## Appendix A – Response to Agency Submissions (SSD 9670) Western Sydney University Innovation Hub – 2-6 Hassall Street, Parramatta

The following table includes a response to the full text of submissions provided by or on behalf of State and local government agencies. For completeness, the full text of each submission is provided in the left-hand column, accompanied by the proponent's corresponding response in the right-hand column. The proponent's responses have been informed by input by the expert consultant team and should be read in conjunction with the publicly exhibited Environmental Impact Statement and accompanying technical reports, as well as the Response to Submissions Cover Letter to which this document is appended.

**DRAWING**  
DETAILS  
Hassall Street Public Domain  
**DRAWING NO.**  
6HS-ASP-L01.07  
**REVISION**  
D

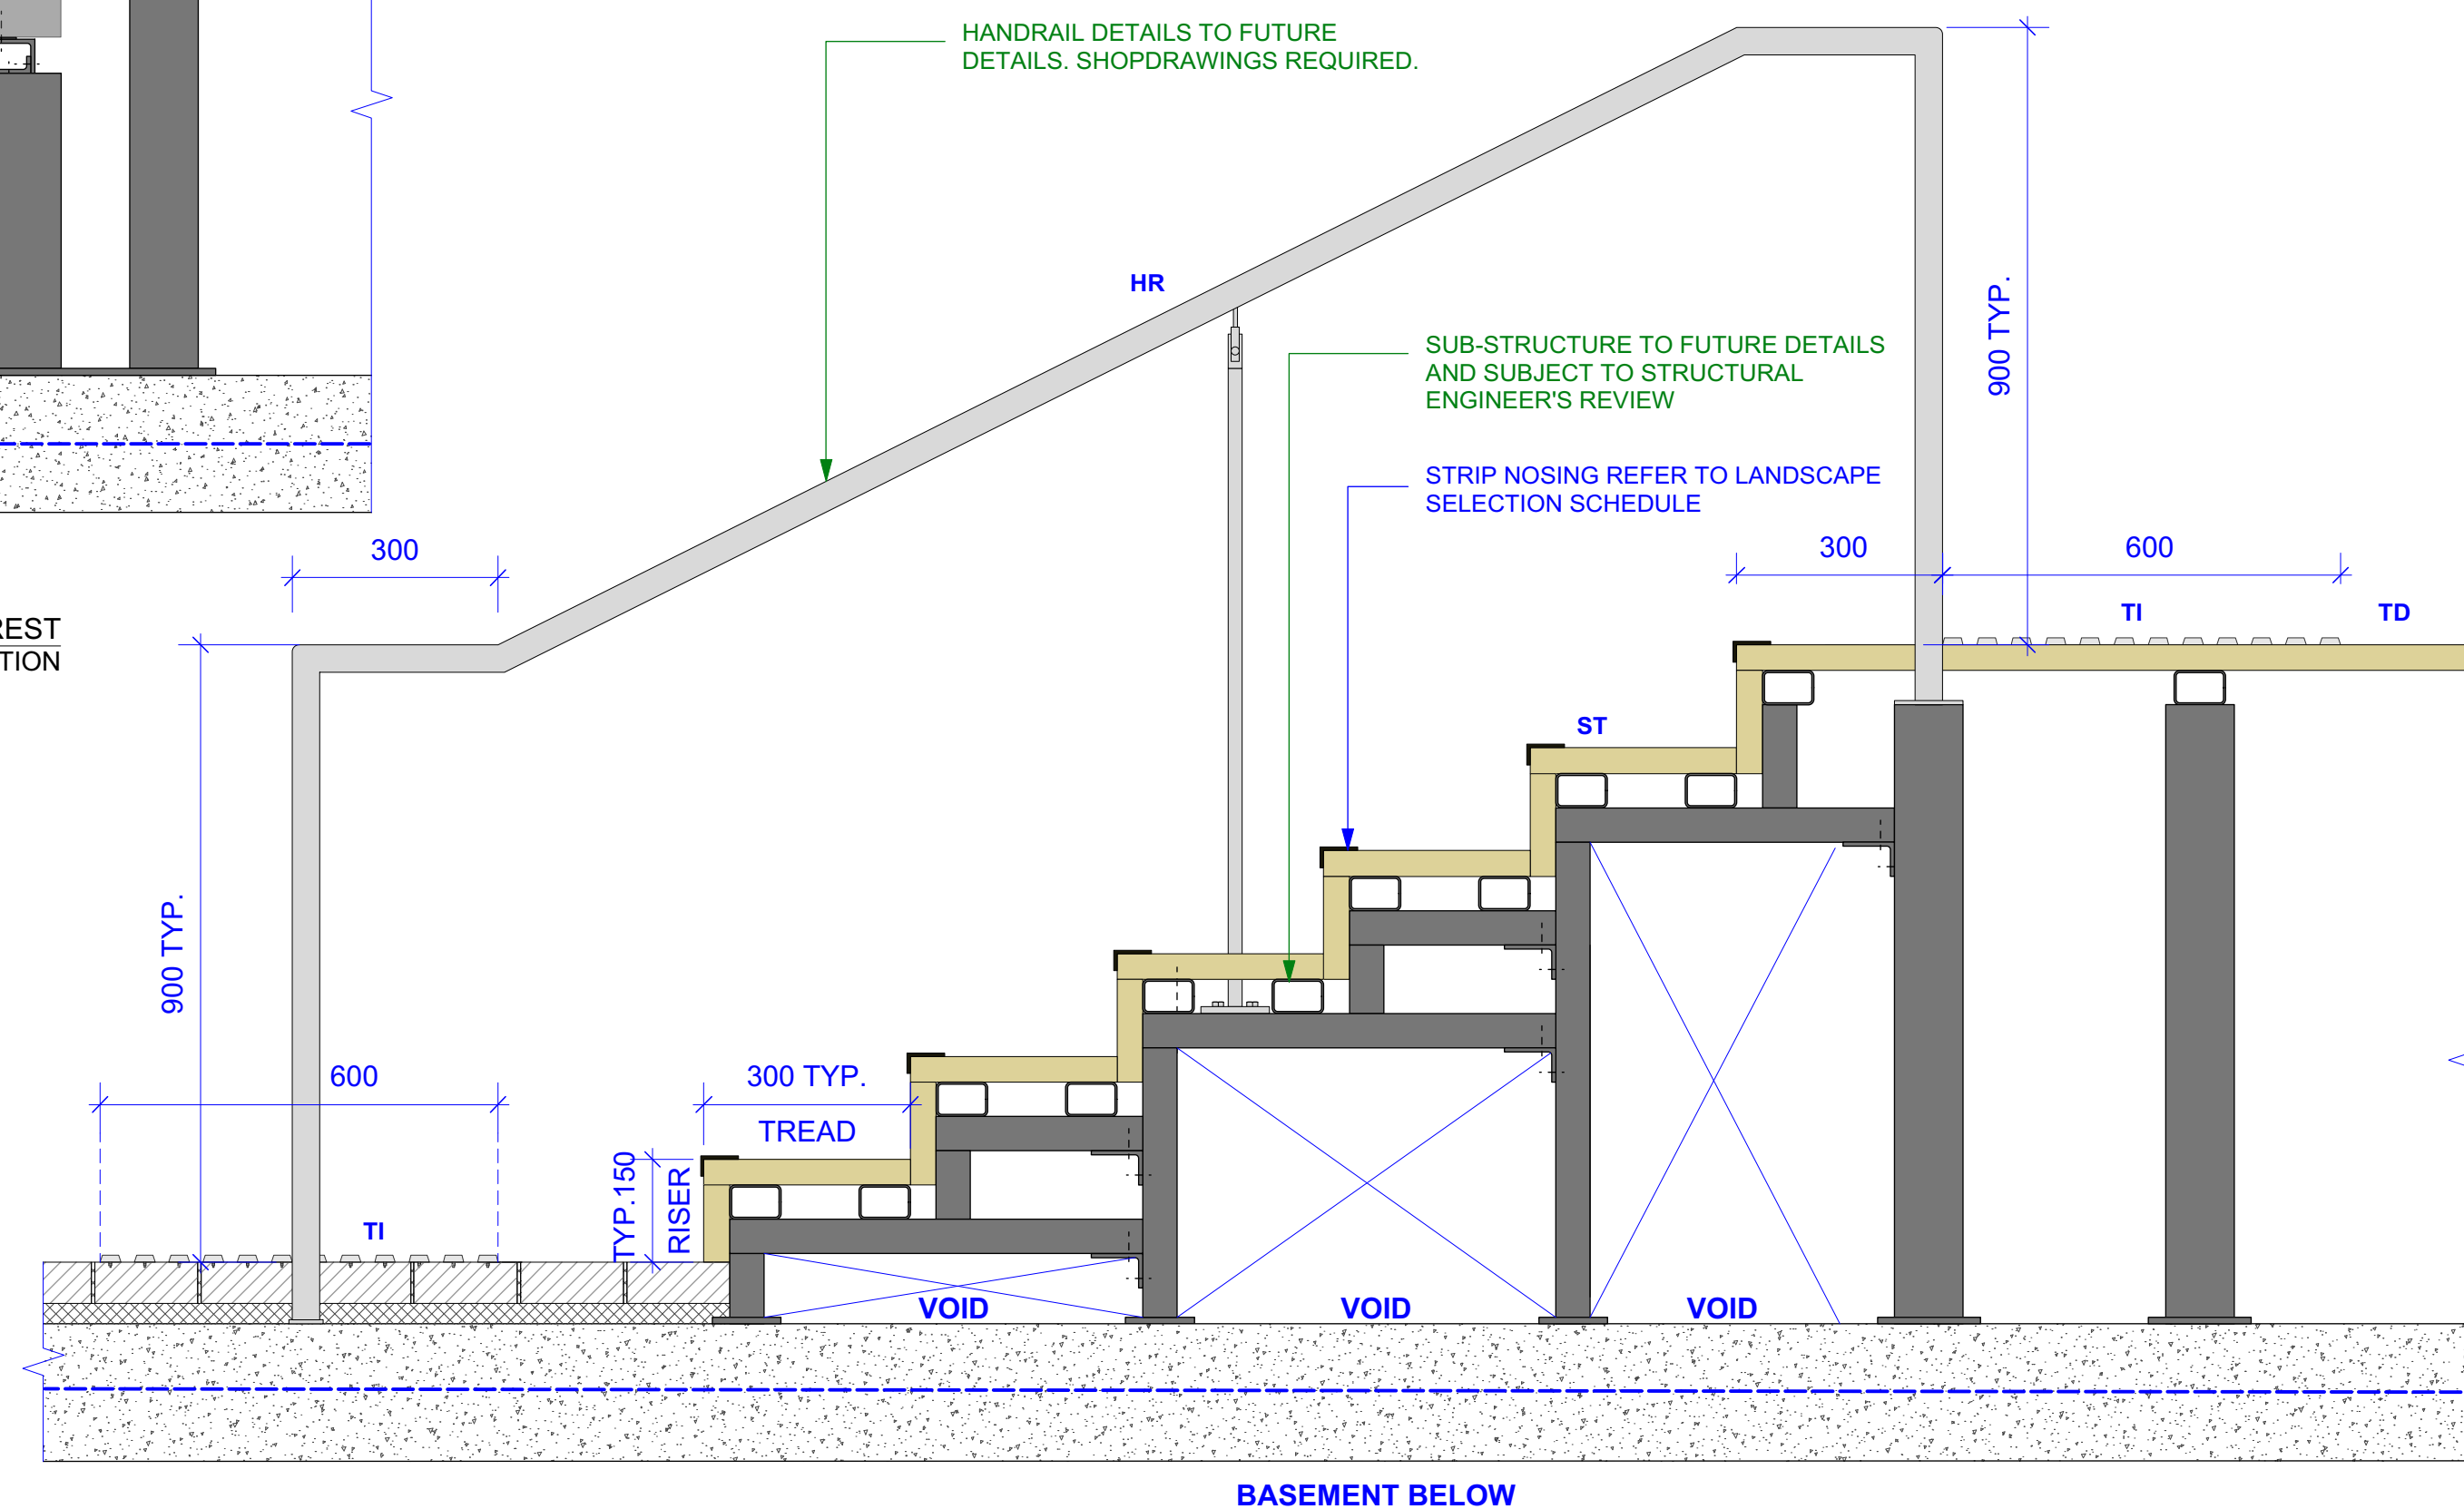
CoP 2e	<ul style="list-style-type: none"> <li>Street tree soil volumes and planting details should be as per the Parramatta Public Domain Guidelines 2017.</li> </ul>	The proposal complies with the Parramatta Public Domain Guidelines 2017. Refer to Landscape Drawing L01.07, detail 11 "Typical CoP Tree Detail" ( <b>Appendix C</b> of the RTS), which includes the extent of Structural soil for street trees and the typical planting details. Please refer to Landscape Drawing L01.04 for the extent with dimensions and L01.07 for the typical planting details. For further details please refer to Landscape Specification.
CoP 2f	<ul style="list-style-type: none"> <li>Street lighting seems to be missing from the public domain plan.</li> </ul>	The ground floor drawing has been amended to show existing streetlight poles.
CoP 2g	<ul style="list-style-type: none"> <li>Explore relocating the substation to next to the retail at the boundary with the Commercial Hotel or in another area. Any required vehicular access to the substation needs to be demonstrated.</li> </ul>	The Design Competition Jury and Endeavour Energy have endorsed the proposed location of the substation on the ground floor. The proposed substation location ensures that the standalone retail building adjoining Commercial Hotel can maintain an appropriate heritage transition whilst maximising activation to the through site link. Any requirement to relocate the substation within this building would compromise these benefits of the design. The location as proposed meets the requirements of Endeavour Energy.

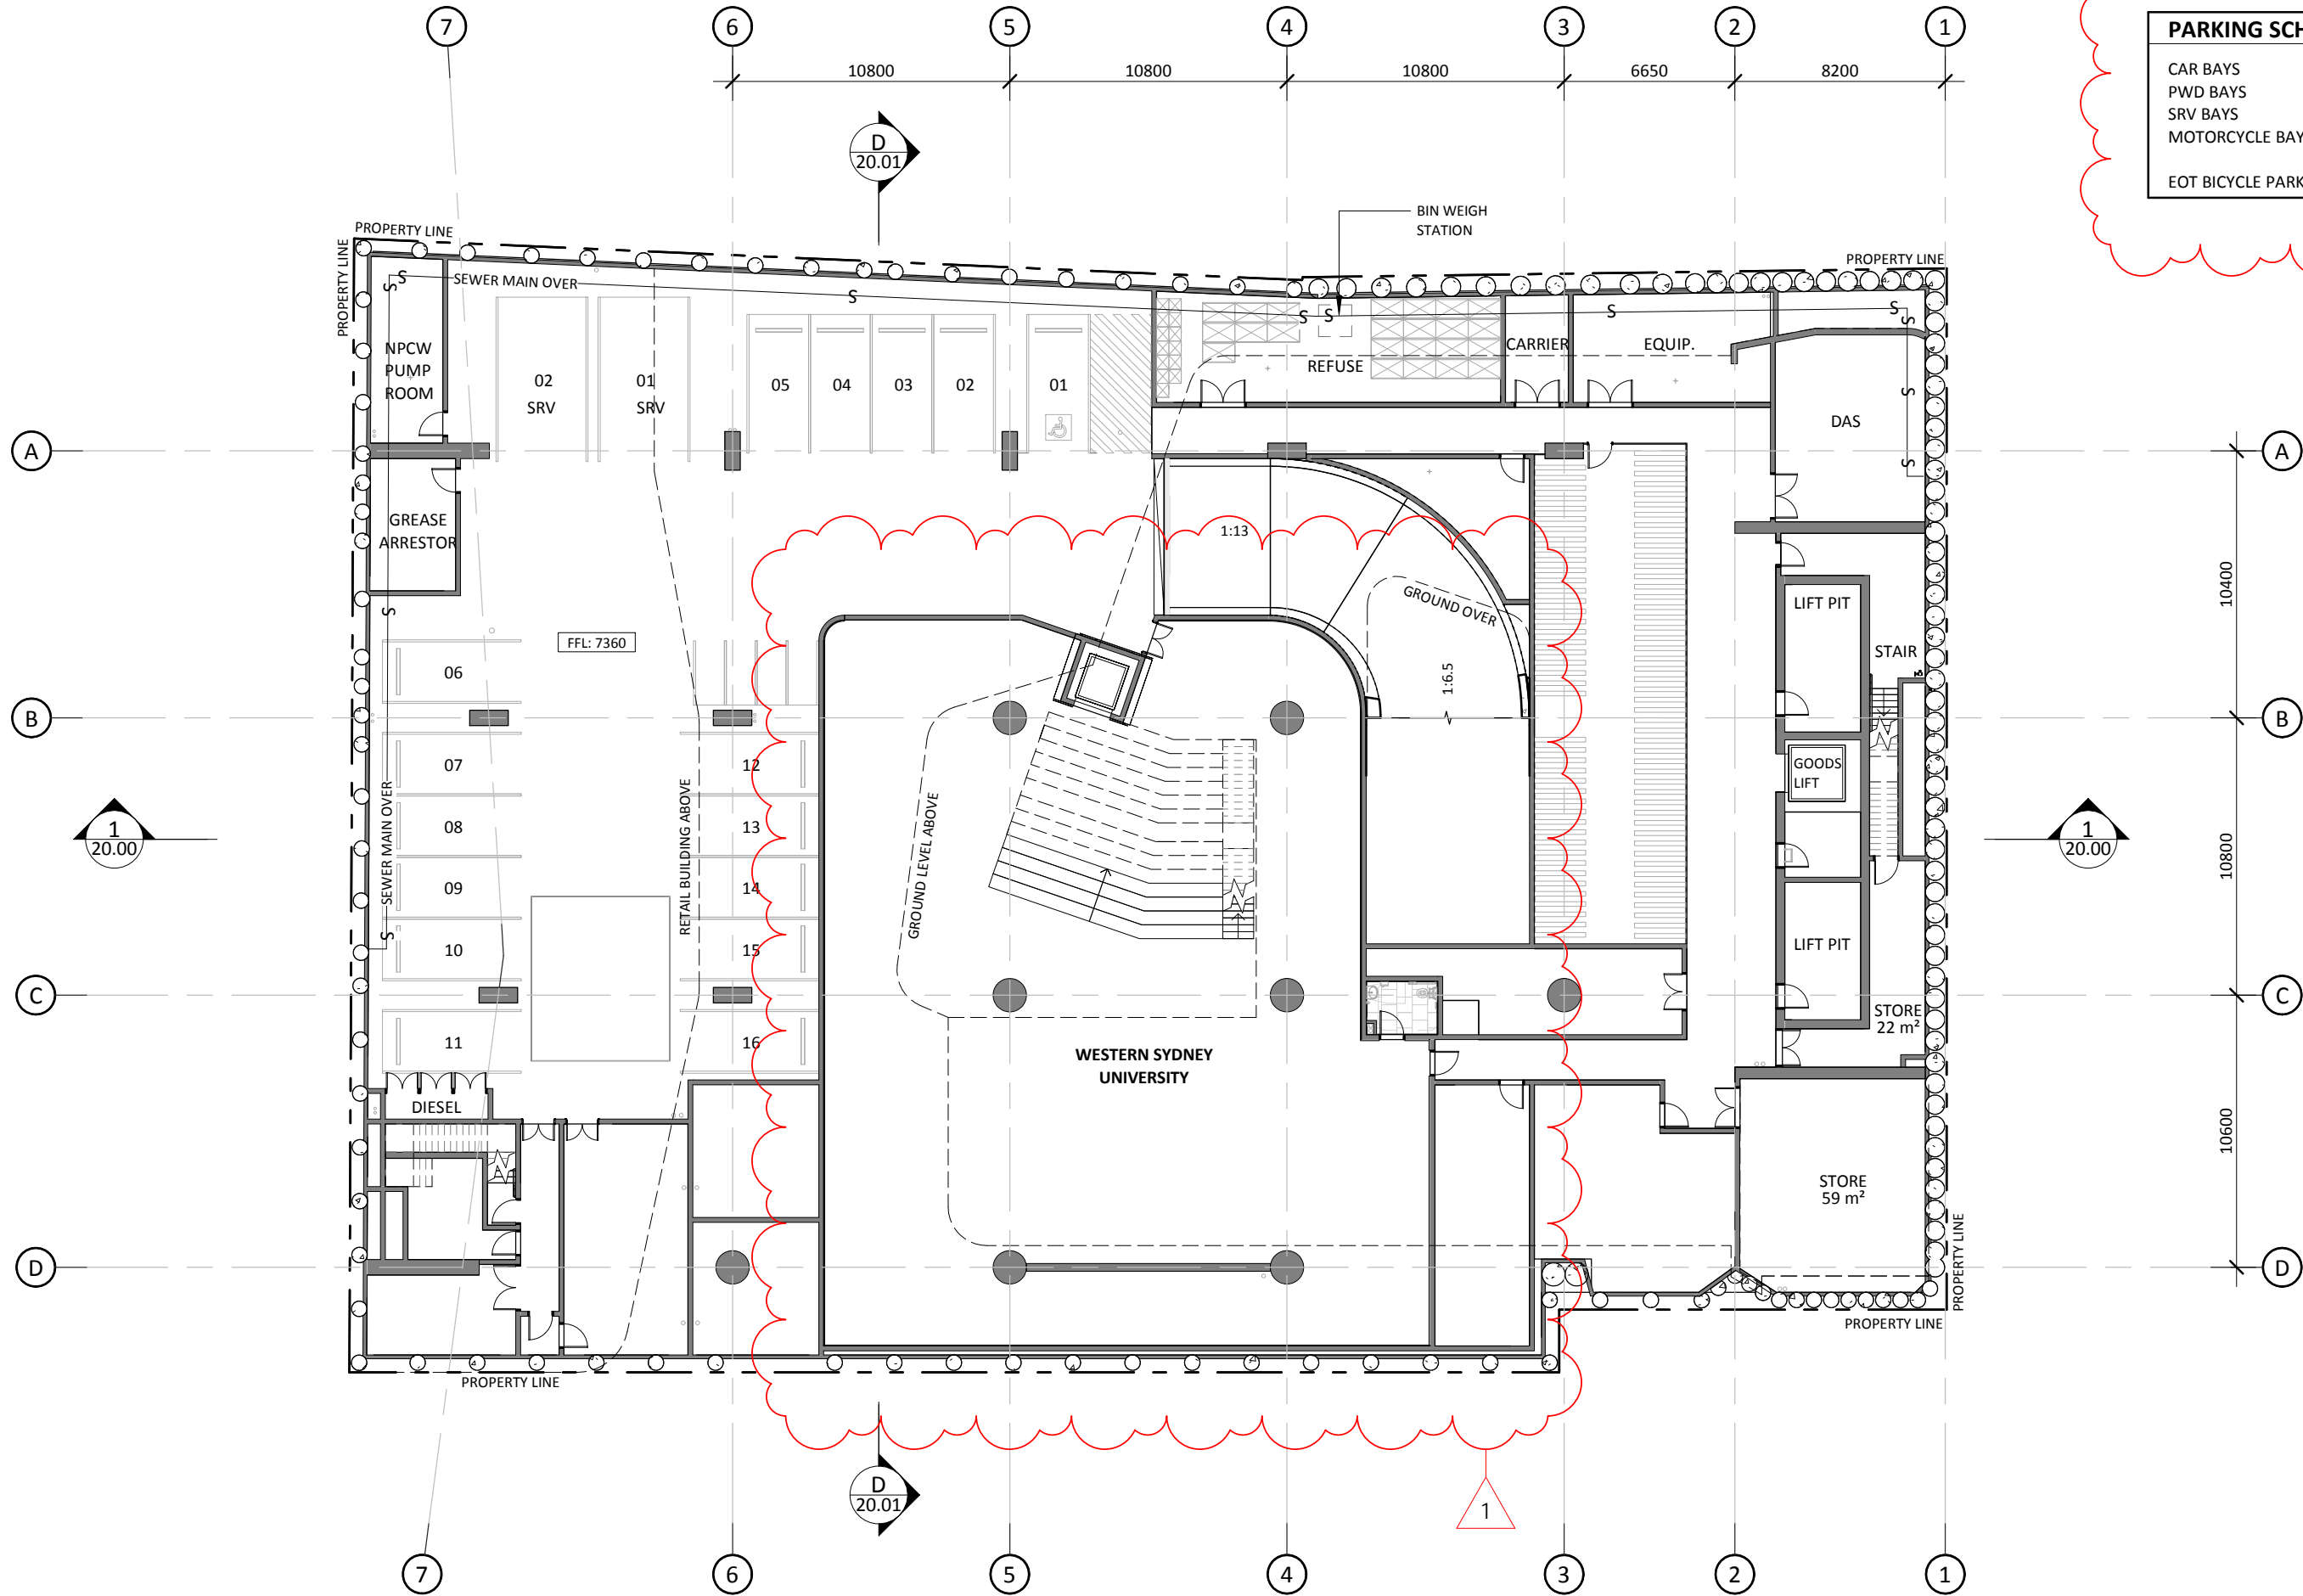
CoP 2h	<ul style="list-style-type: none"> <li>Ensure slabs within apparent public domain are separate along the property boundary and that the property line is demarcated within the public domain in some manner.</li> </ul>	Expansion joints along property line added on Architectural Drawing 10.01.
CoP 2i	<ul style="list-style-type: none"> <li>Ensure water positively drains away from the building edge and property line. Detailed levels are required to demonstrate this.</li> </ul>	Plaza finish floor levels (FFL) added to Architectural Drawing 10.01.
CoP 3a	<p><b>Universal Access Requirements Ground Floor:</b></p> <ul style="list-style-type: none"> <li>All doorways from the retail areas leading to the plaza must provide low level thresholds with a construction tolerance of no more than 3mm.</li> </ul>	Retail FFL and Plaza FFL added on Architectural Drawing 10.01 showing flush thresholds.
CoP 3b	<ul style="list-style-type: none"> <li>Ensure the doors from the retail areas leading to the plaza provide a clear opening of 850mm including the active leaf of any set of double doors.</li> </ul>	Dimension added to retail entry doors on Architectural Drawing 10.01.

CoP 3c	<ul style="list-style-type: none"> <li>Ensure there is the correct latch side clearances for the doors leading to the amenities.</li> </ul>	Required DDA clearance for latch side clearance added to Ground Floor DDA bathroom. See Architectural Drawing 10.01.
CoP 3d	<ul style="list-style-type: none"> <li>Ensure the bleachers also provide an area of accessible seating including compliant arm and back rests.</li> </ul>	Refer to Landscape Drawing L01.08, detail 5 "Timber Deck / Back Rest and Arm Rest".
